Rezoning Transportation Analysis

Petition Number: 2020-067

General Location Identifier: Tax ID 09505544

Date	Description
05-18-20	First Review
06-25-20	Second Review (TV)

SCHEMATIC ILLUSTRATIVE SITE PLAN

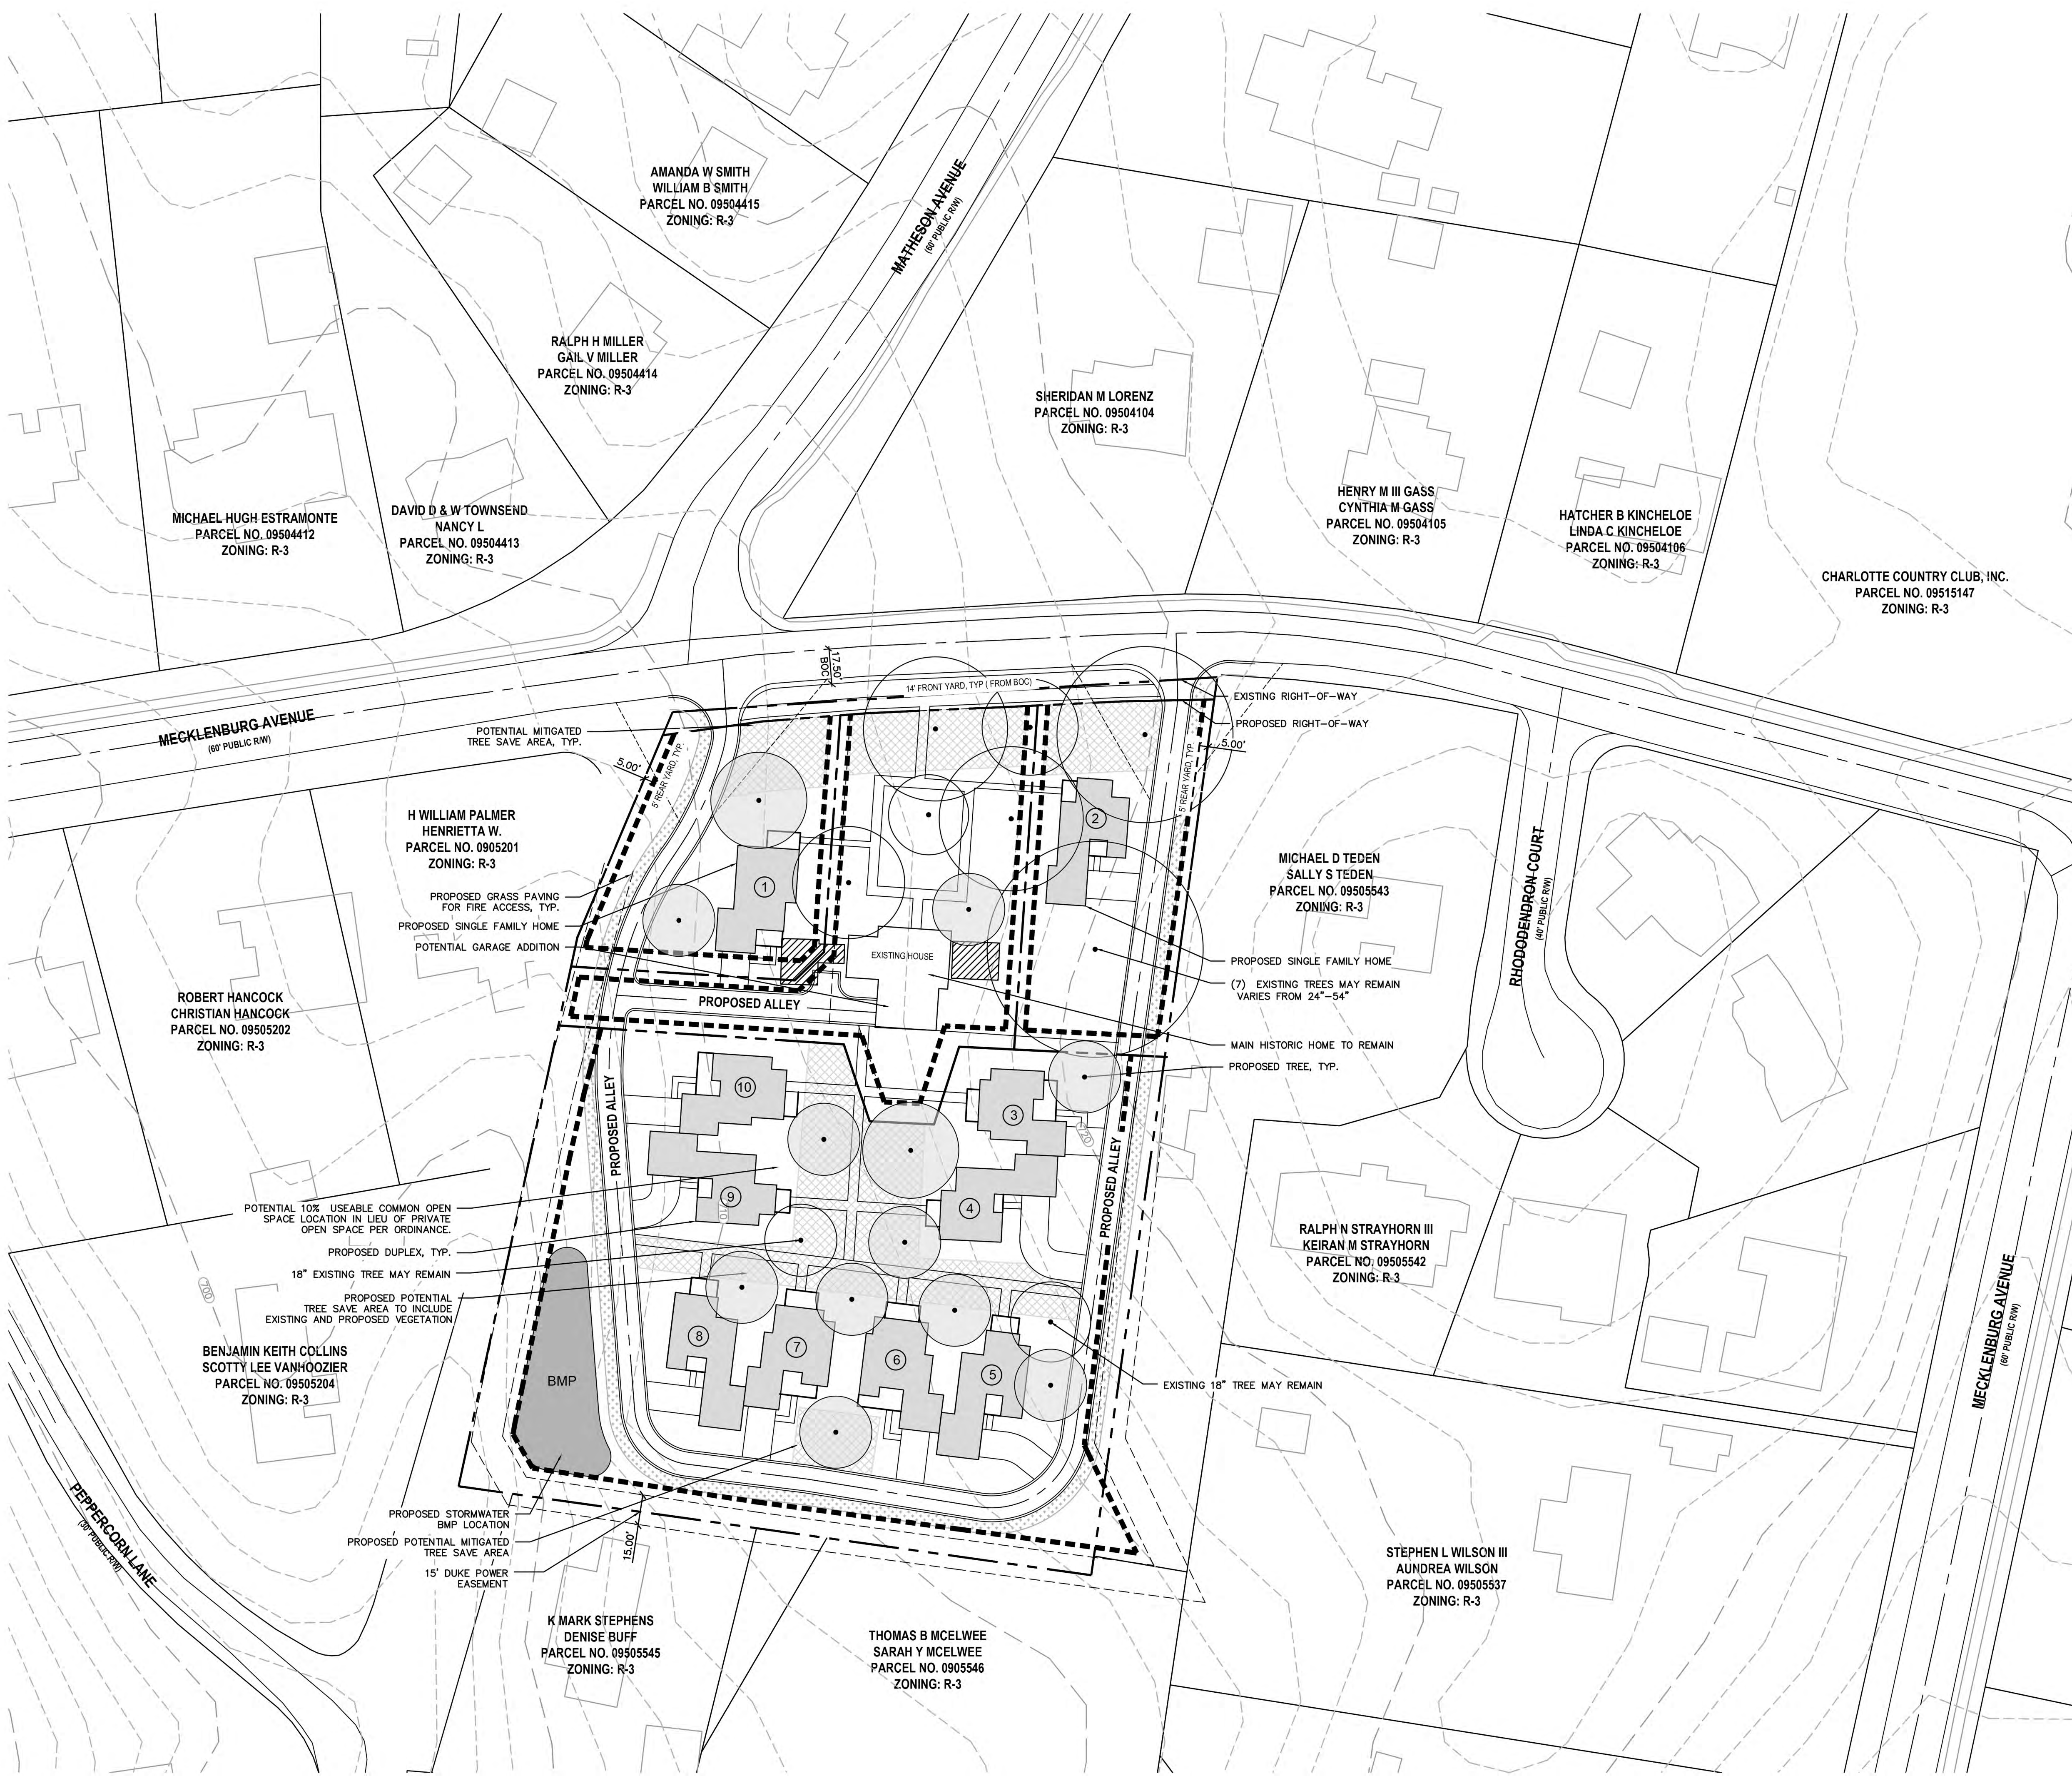
- ~~**Curblines**~~ The proposed zoning district has a setback measured from back of the existing or proposed future curblines.
 - ~~**Mecklenburg Avenue:**~~ The existing back of curb and gutter should be relocated 17.5' from the centerline.

The site plan should show the curb and gutter labeled and dimensioned from the centerline for each road.
- ~~**Traffic Study**~~ A Traffic Impact Study is not necessary for the complete review of this petition. If during the permitting process the site generates more than 2500 daily trips, then a traffic study will be required.
- The petitioner should revise the site plan and conditional note(s) to commit to constructing an 8-foot planting strip and a 6-foot sidewalk on Mecklenburg Avenue per Chapter 20 Subdivision. The site plan should label and dimension both items from the back of curb and gutter and road centerline.

- The petitioner should revise the site plan and conditional note(s) to commit to constructing a public street, Matheson Avenue south of Mecklenburg Avenue, as a Local Residential Medium with an 8-foot planting strip, and 6-foot sidewalk per Chapter 20 Subdivision ordinance.

Reference (CLDSM standard detail U-03A) for street typical.

7. The petitioner should revise the site plan to add a note specifying dedication and fee simple conveyance of all rights of way to the City before the site's first building certificate of occupancy is issued. CDOT requests right of way set at 2' behind back of sidewalk where feasible.
